Current Zoning: NS (neighborhood services), B-1(CD) (neighborhood business, conditional), and N1-A (neighborhood 1-A)
Proposed Zoning: UR-2(CD) (urban residential, conditional)

Approximately 13.50 acres located at the northeast intersection of Albemarle Road and Novant Health Parkway, west of Cresswind Boulevard.

Wood Partners

PLANNING STAFF REVIEW

ILLUSTRATIVE SITE PLAN
FOR
PETITION # 2022-066
ALBEMARLE ROAD APARTMENTS
CHARLOTTE, NORTH CAROLINA

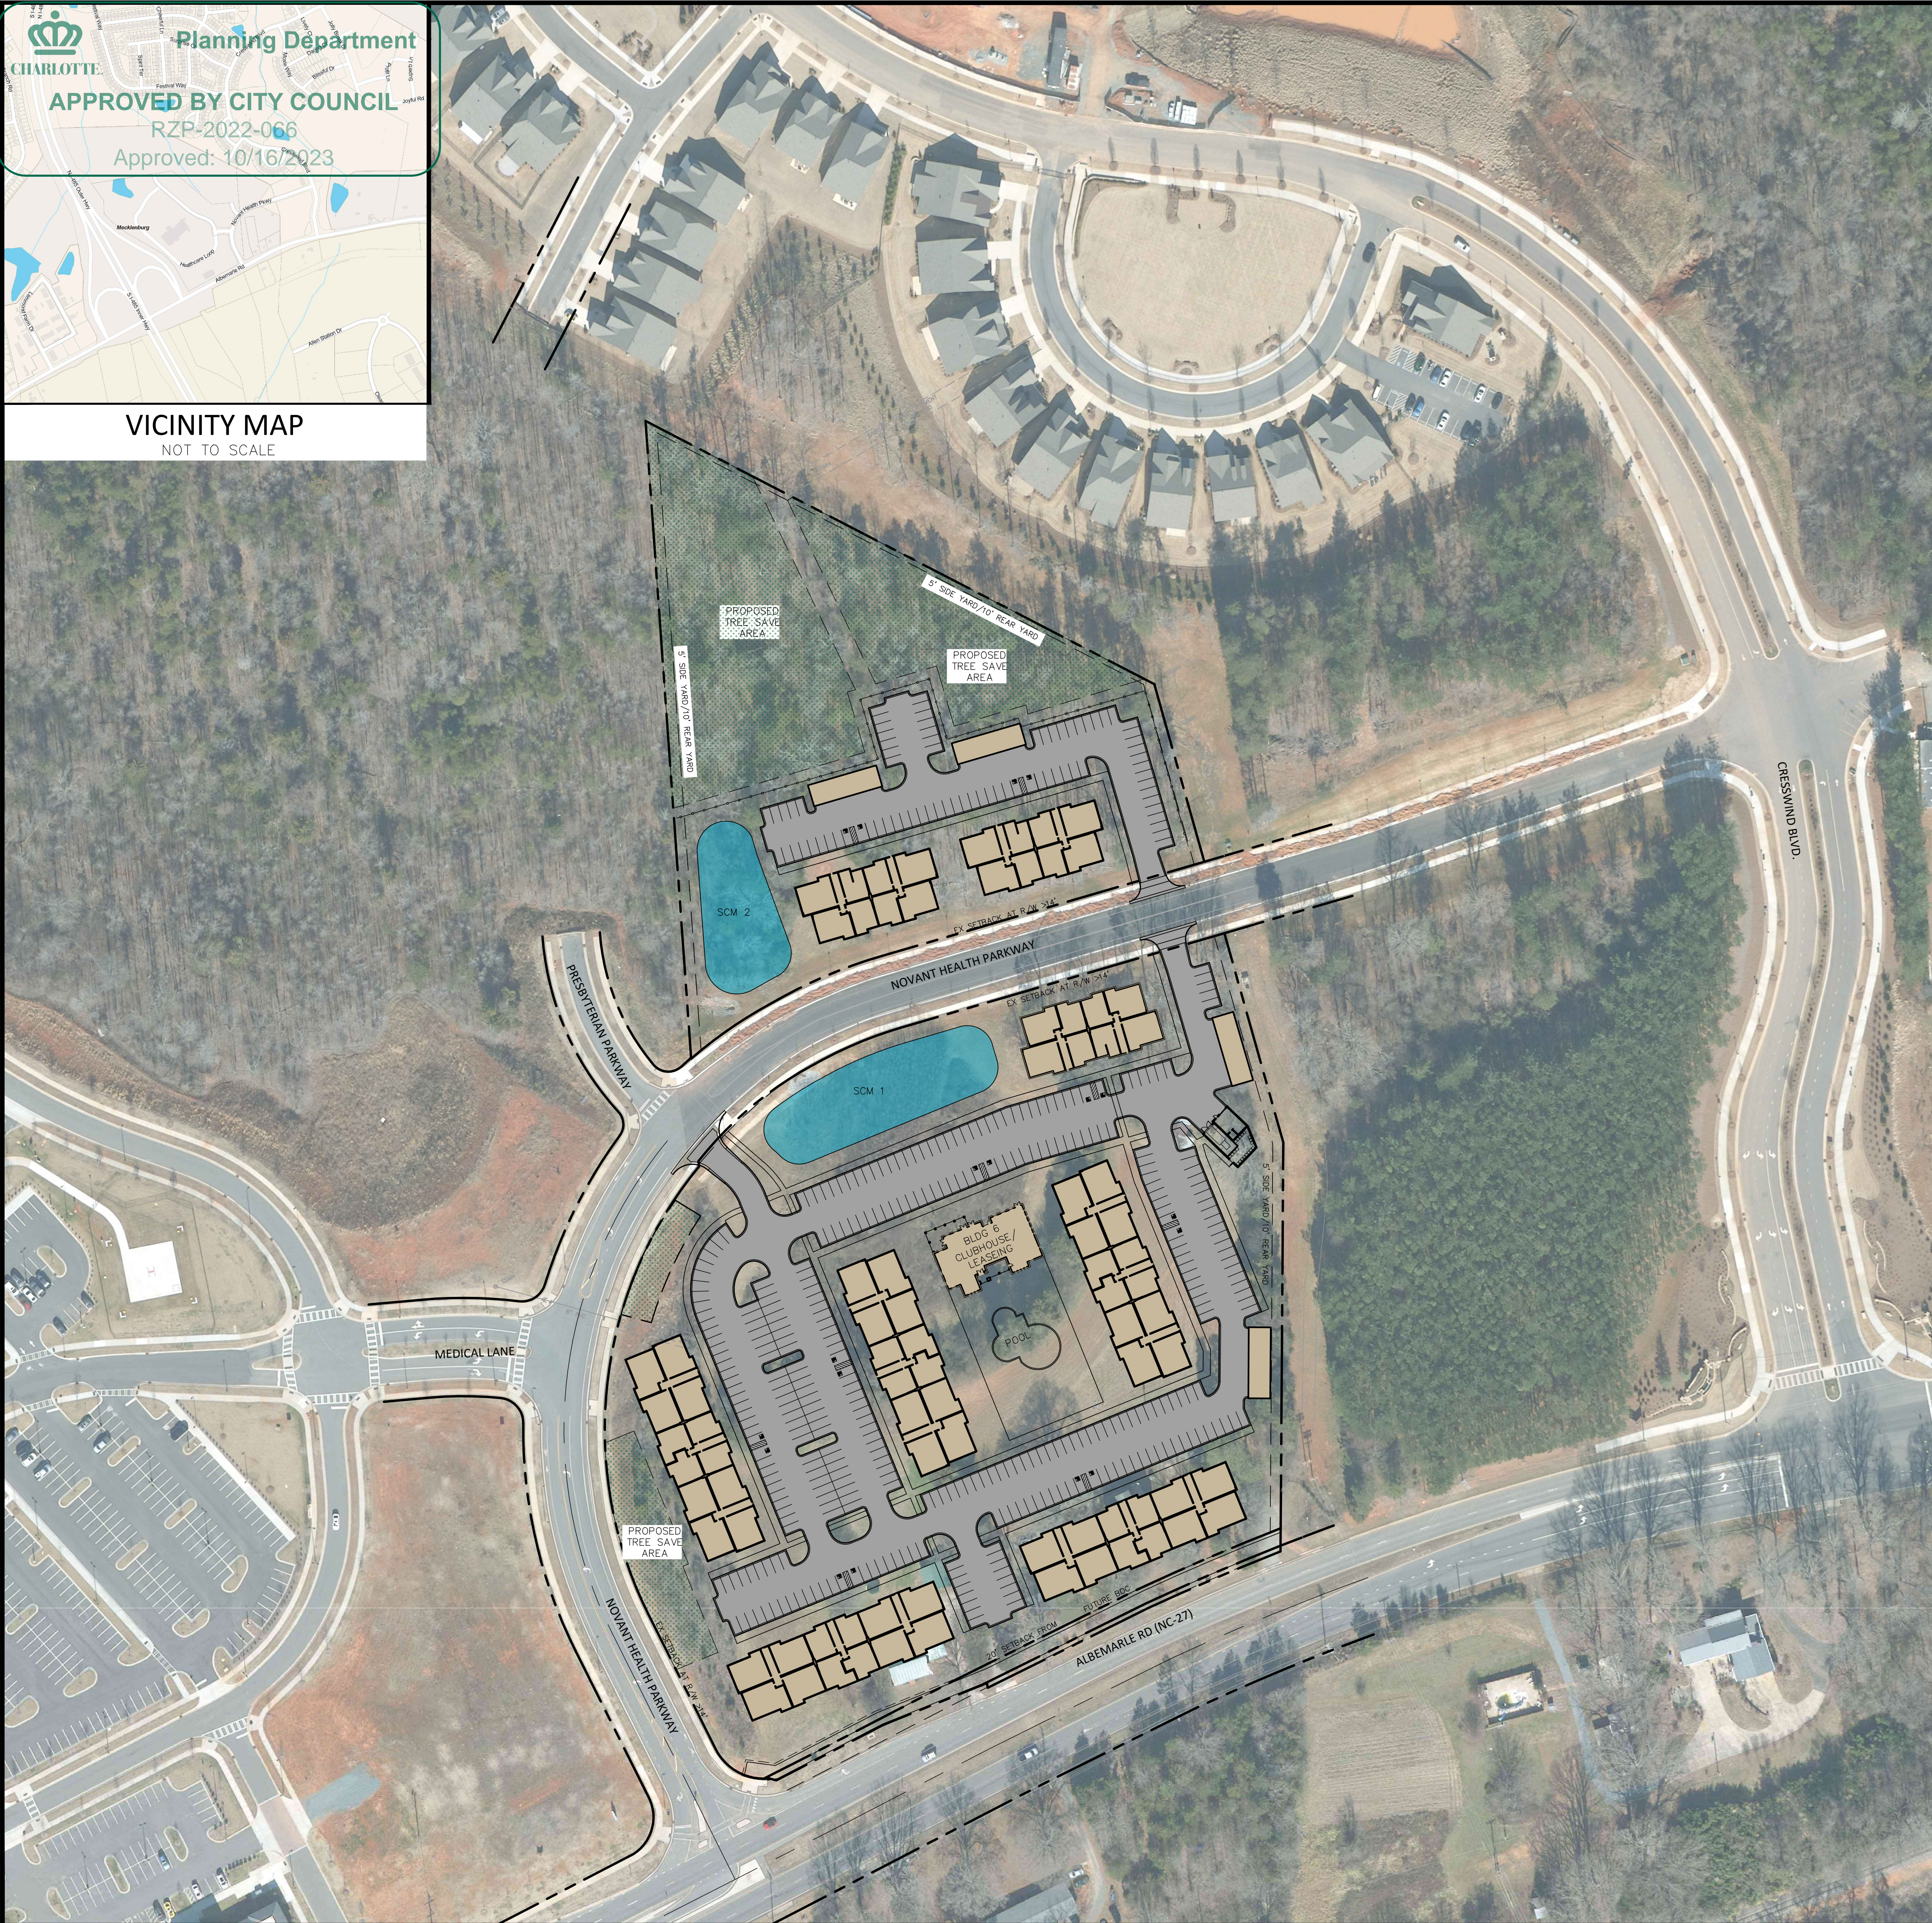
- ~~1. Revise site plan and conditional note(s) to commit to dedicate 100 feet of right-of-way or existing right-of-way, whichever is greater from the road centerline of Albemarle Road. The site plan shall label and dimension the right-of-way from the road centerline of Albemarle Road and Novant Health Parkway.~~

- ~~2. Tree save must meet all standards. Easements are not permitted in tree save areas. Remove this statement because it does not follow the ordinance.~~

- ~~3. Confirm if the clubhouse is referenced/committed to in the development notes.~~
- ~~4. Possible BMP areas are located along Novant Health Parkway. Approved plant materials should be provided so the areas serve to add to community character.~~
